From:
Sent: 28 November 2020 10:11
To: Neil Bearcroft <Neil.Bearcroft@kirklees.gov.uk>
Subject: 402 Birkby Road

CLIENT:	
ACUMEN	
JOB TITLE:	
GATEPOSTS AT 402 BIRKBY ROAD, HUDDERSFIELD	
DRAWING TITLE:	
PROPOSED SITE PLAN & ELEVATION	
DRAWN: JF	DATE: Sep
CHECKED: JC	SCALE: 1:200 @ A1
DRAWING NUMBER:	2532 - 12

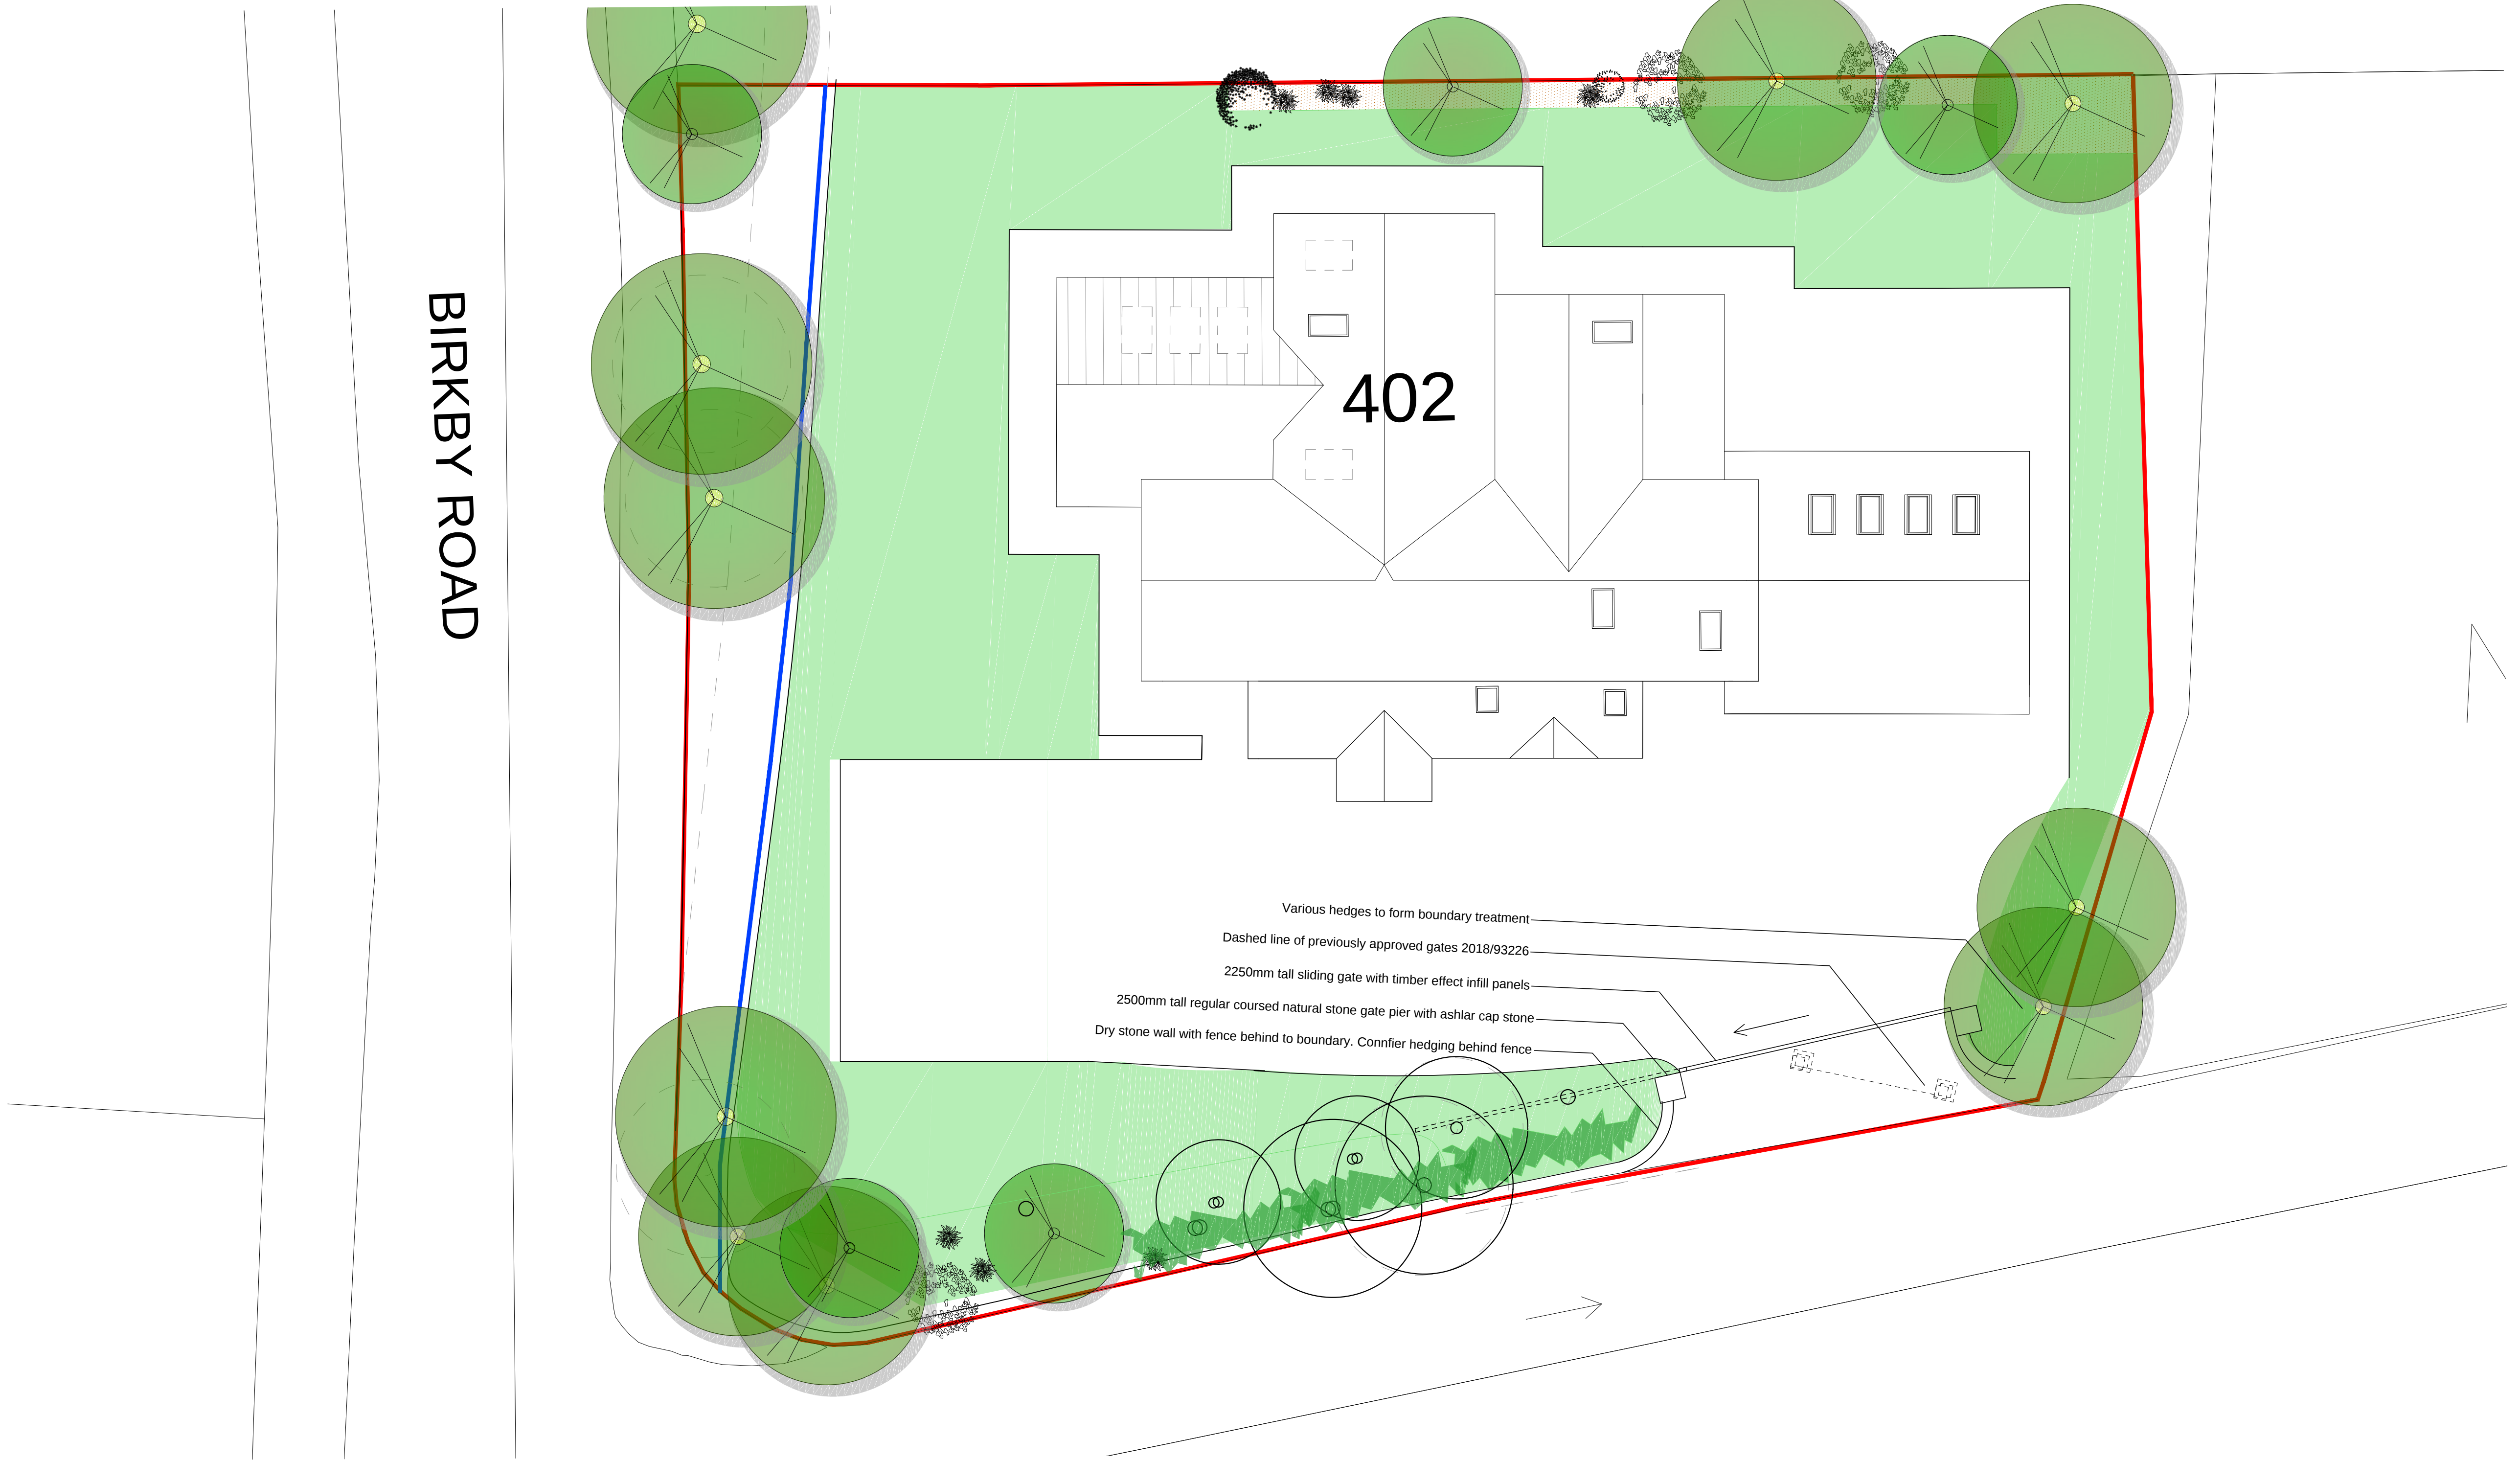
It appears from the submission that the fence shown on the proposals and that currently exists on the site has not been included in the application. The height of the fence is measured from the highest part of the adjacent land which is the existing garden level in No 402. It may be that the existing fence does not exceed 2m in height and may have been assessed as Permitted Development and is therefore not included in the applications, however this is actually not the correct case.

Under the correct interpretation of the status of the access drive which is as a highway for the purposes of planning, the Permitted Development limit would be 1m. Therefore the proposal is currently significantly higher than this and this is a material factor in the planning considerations.

As it is the case that the side fence should only be 1m high measured from the garden side then the current fence does not benefit from PD rights and needs PP in which a proper assessment of the visual impact needs to be made.
